Our Ref: DA S29/3/97-MOD-1

**Eastern Creek Karts (DA S29/3/97)
Section 4.55(2) Modification for Earthworks and Drainage (MOD 1)**

Attachment 1

Map Title / Figure:

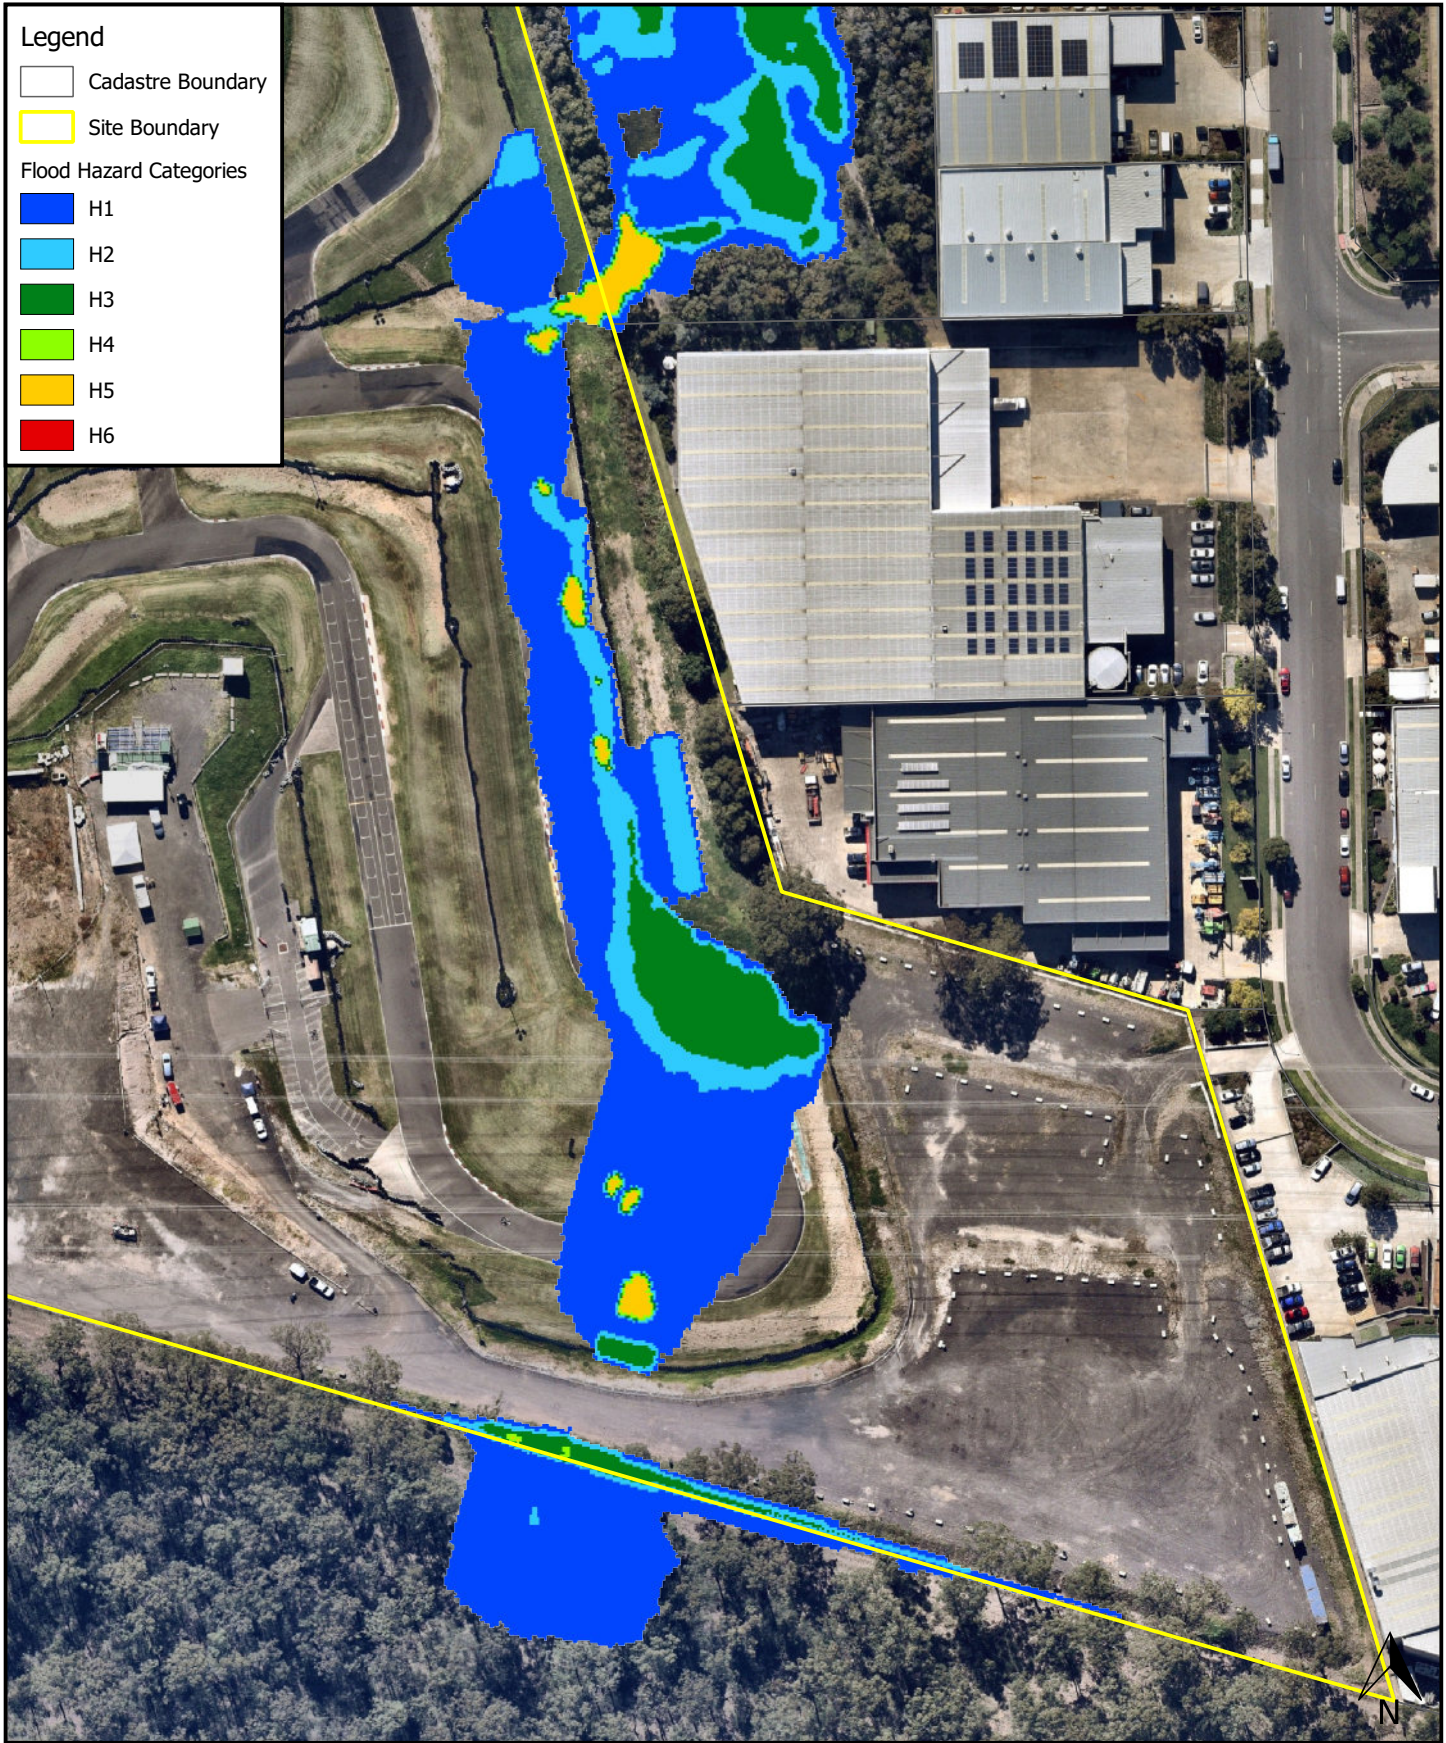
- 2.4 Clarify if the proposed finish level of the access ramp over culvert 1A102 is 0.67 m above the toe of the upstream batter and clarify if TUFLOW Plan FL04 dated 16 April 2021 still requires the PMF to flow over the top batter as shown. If this is the case, please clarify PMF design peak flood depth and velocity over the access ramp.
